Application for Planning Permission for Works or Extension to a Dwelling

Development: Proposed flat-roof single storey rear extension to form sun deck with perimeter obscure glazed balustrading accessed via external spiral staircase, proposed elongated windows to western elevation and erection of double carport to replace garage.

Location: 4 Sea Lane Ferring BN12 5DS

25.313 Drawing: PL03C

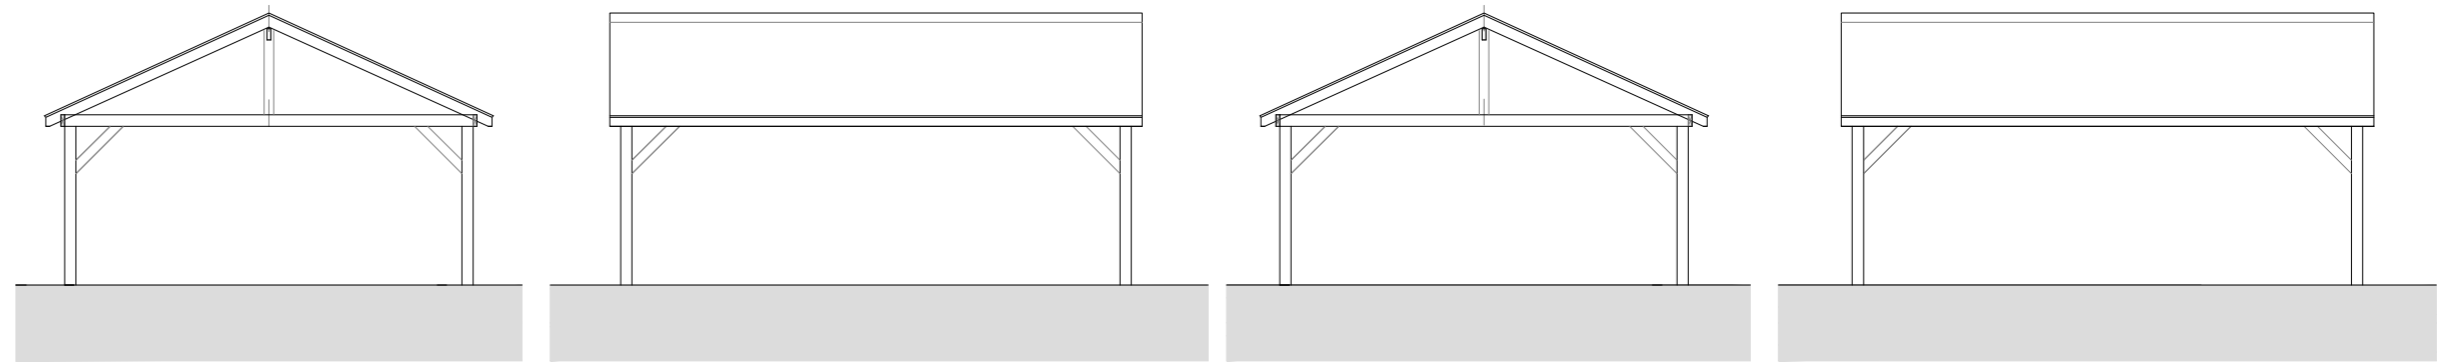
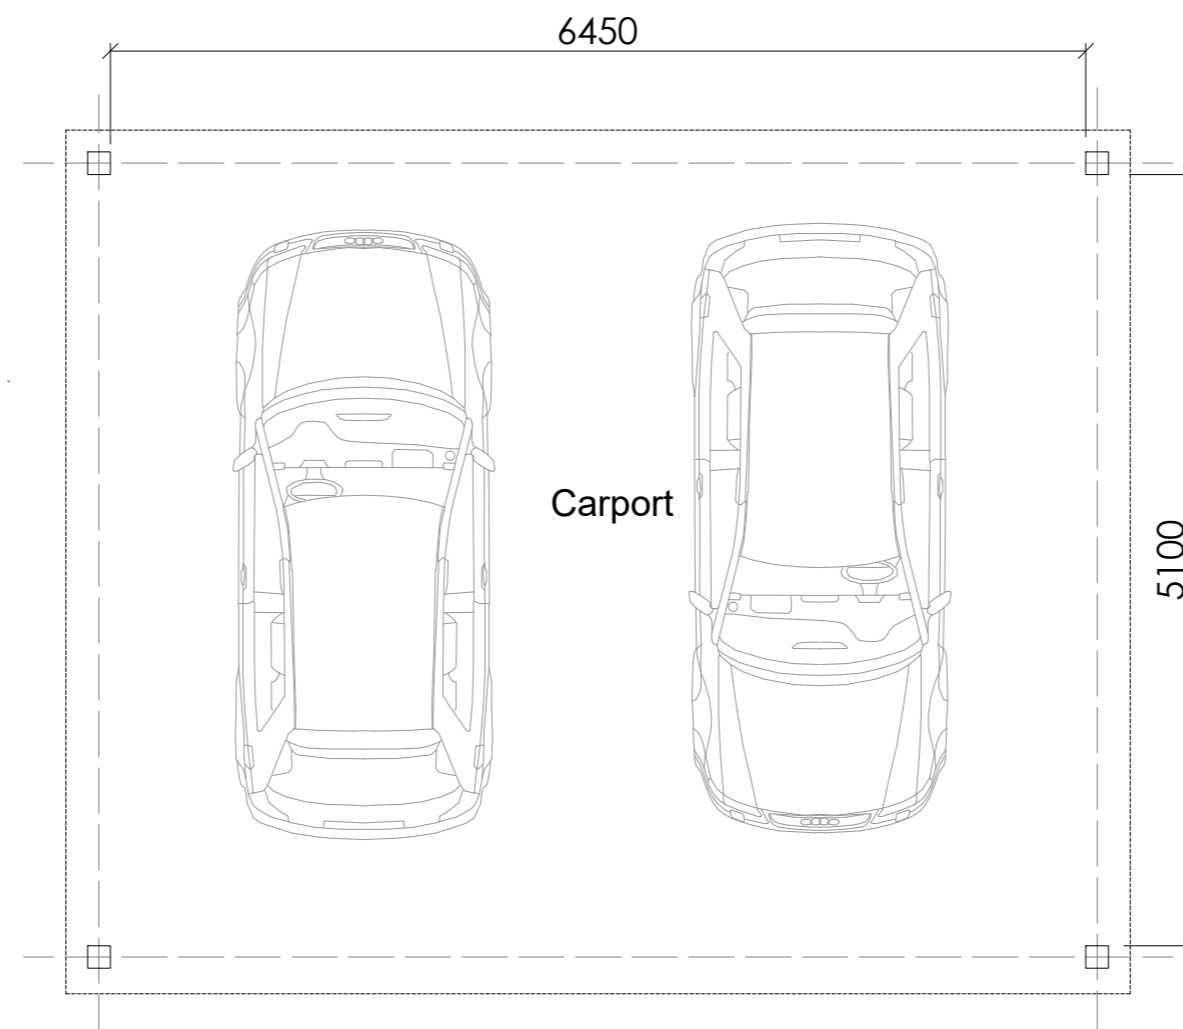
Please add the proposed side porch canopy and front gate to the description of works, or with your permission, we can add this for you.

Please submit electronic plans in pdf format clearly labelled proposed gate elevations at a scale of 1:50 or 1:100. Further details can be found in the Validation Requirements List.
